Harnett County Government Complex
307 Cornelius Harnett Boulevard
Lillington, NC 27546

November 2, 2007

Re: Status of Improvement Permit Application #07-5-18486

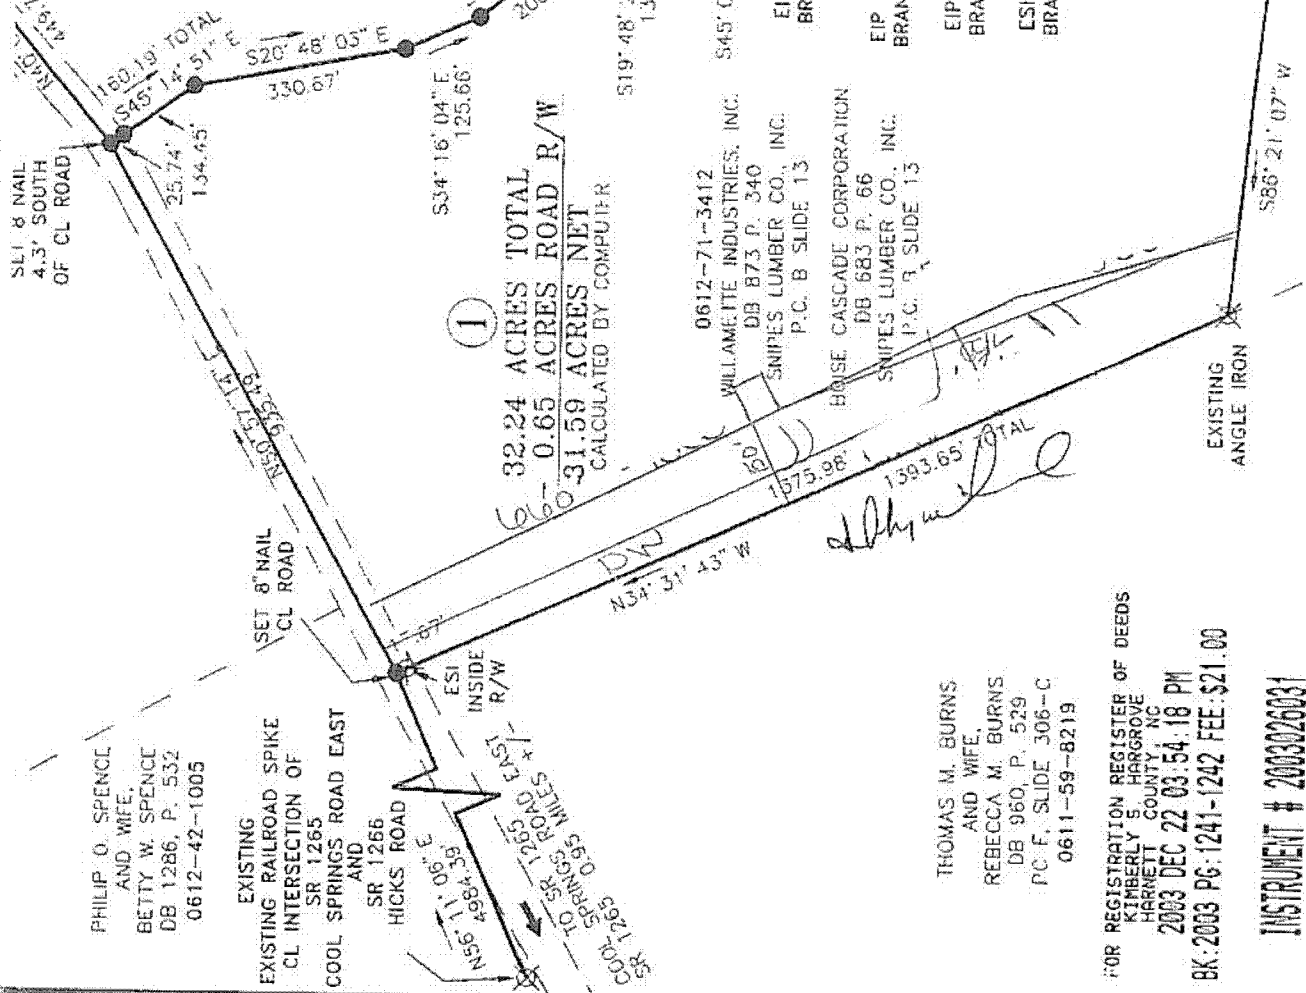
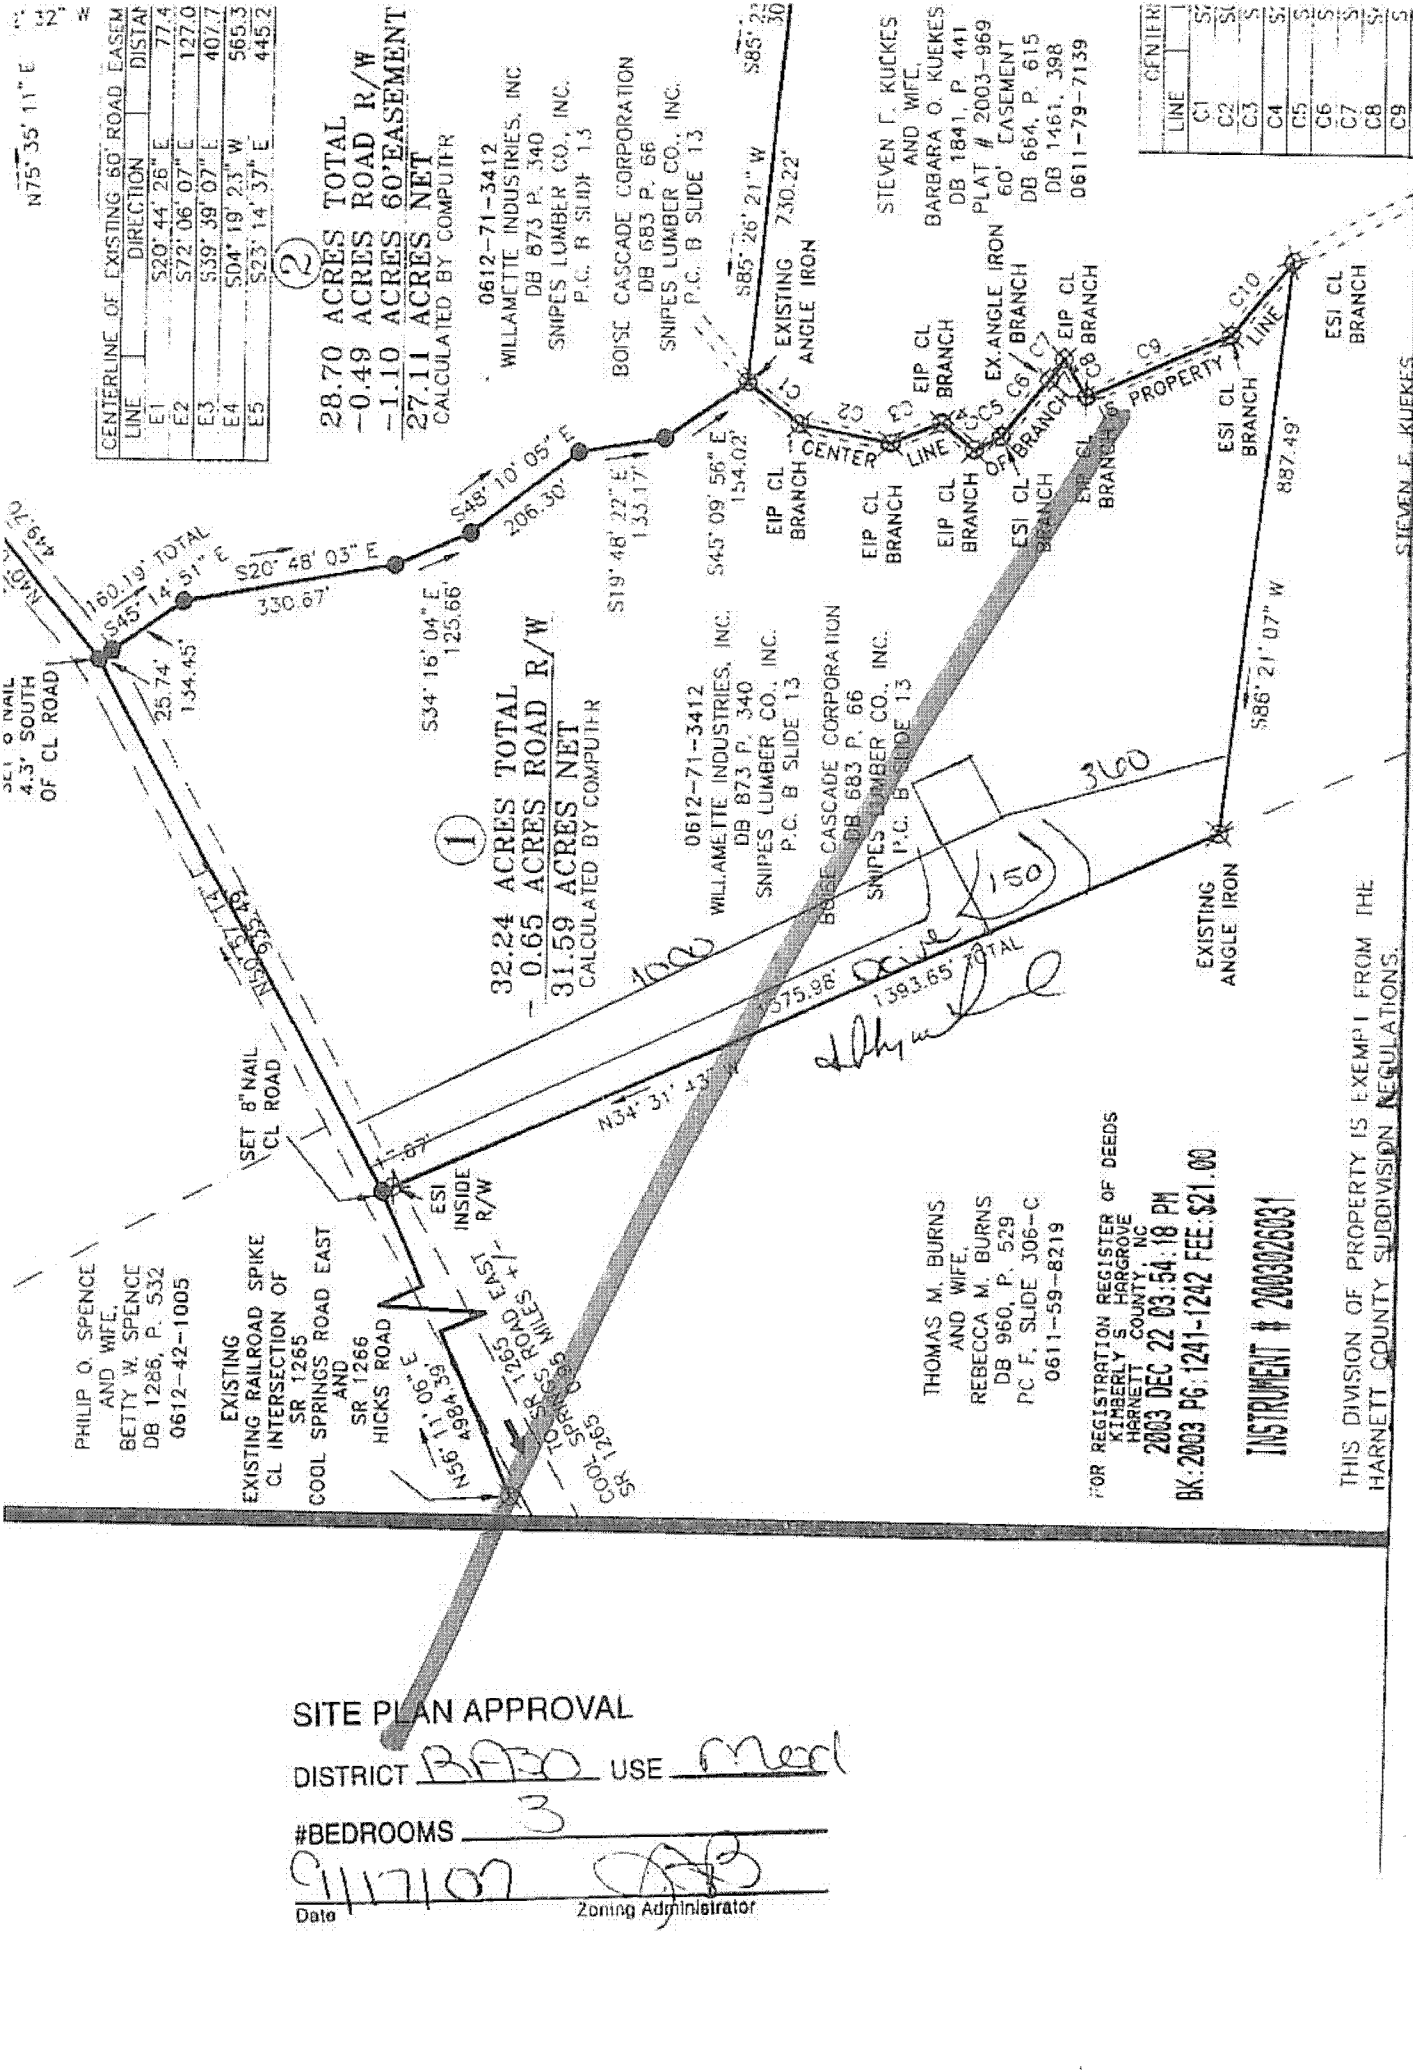
- 1. Property lines/corners not marked or labeled
- 2. House corners not marked or labeled
- 3. Directions not clear to property
- 4. Property needs brush or vegetation removed
- 5. Backhoe pits required
- 6. Other – Move home site as shown and submit new plot plan to Central Permitting as a revision.

Please STAKE new
House location
And submit new
plot plan To Central
Permitting.
Once This is done
I need to meet
Someone on site
Before permit can
be Issued.
